TECHNICAL NOTE

Reference: P0421t03v02

RE: Revised Response to Submissions – Ivanhoe Estate, Macquarie Park (SSD 8707)

**Figure 1: SIDRA Network without left-in access at Epping Road**

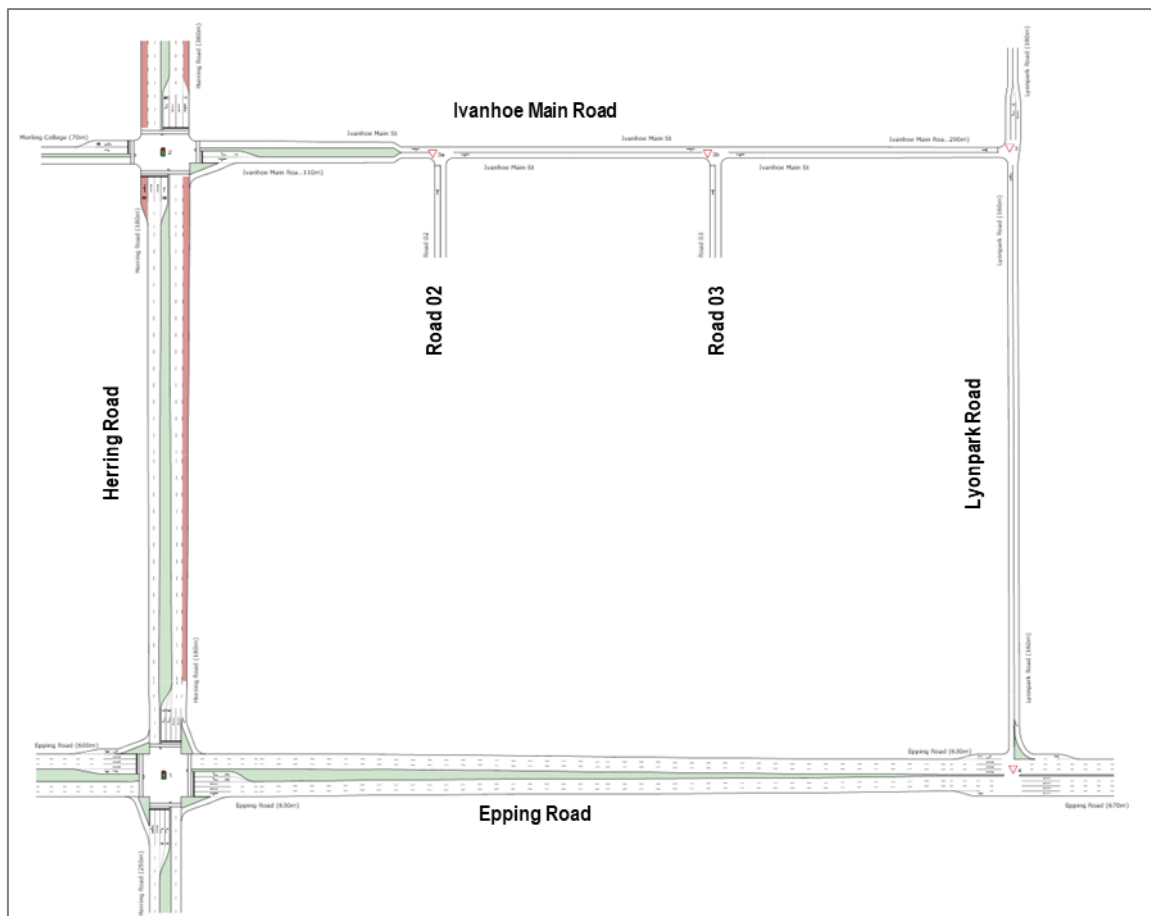
Provide detailed traffic information that compares the operation of the proposed estate and surrounding road network, both including and excluding the proposed new access road from Epping Road.

SIDRA analysis of the two main intersections along Main Street demonstrating the proposed layout is appropriate to accommodate future traffic flows. The Department requests the analysis also considers a scenario that excludes the proposed new access road from Epping Road.

It is understood that, following discussions relating to the environmental impacts associated with the proposed new Left-in (LI) access from Epping Road, this infrastructure upgrade has now been removed from the Proposal. The operation of the road network under the revised access strategy, has been included in the assessments below.

The proposed removal of the LI access has been further analysed in our SIDRA network model and the performance of nearby intersections are summarised in **Table 1** and **Table 2** for 2021 and 2031 scenarios respectively. Traffic that would otherwise use the LI access was re-assigned to access the Site via Herring Road.

It is evident from the results in **Table 1** and **Table 2** that the proposed removal of the LI access would result in increased delays at the Epping Road / Herring Road intersection up to 10 seconds during each scenario assessed. At the intersection of Herring Road / Ivanhoe Place, increase in delay is noted during the PM peak (up to 18 seconds), while the AM peaks for both scenarios would perform somewhat similar.

The results demonstrate that both intersections on Main Street will operate with acceptable levels of service under the future development scenarios for both the 2021 and 2031 horizon years. For clarity, this analysis also assumes the removal of the previously included left-in access from Epping Road.
